Removal of existing garage (at front of property) and re-sitting of garage at rear of property.

64 St Thomas Drive Pagham

Thank you for your internet representation made on 13th June 2011 which has been recorded as **an objection** with the comments as follows:

Title : Proposed South & East Elevations
Address : 64 St Thomas Drive, Pagham.
Date : 05,04,11
Scale : 1:100
Dng.No : PE06

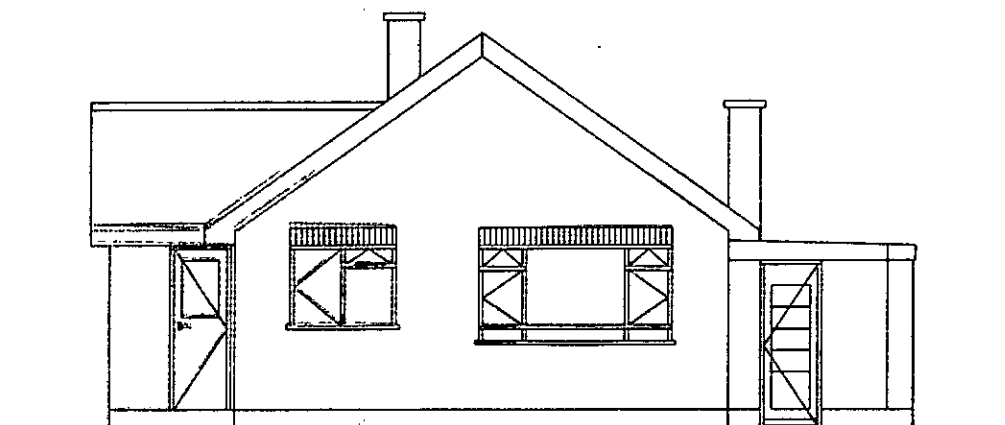
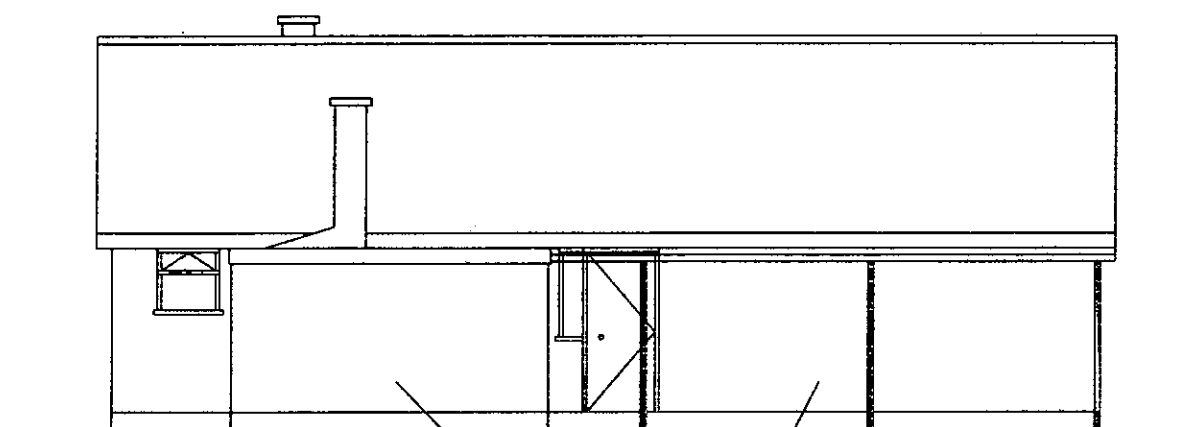
The application does not indicate in sufficient detail the construction of the car port which will be directly adjacent to the lounge window of the adjoining property ☐

The construction of the store, because of its size and position will significantly and adversely affect the natural lighting into the existing dining area, thereby reducing the amenity of the property ☐
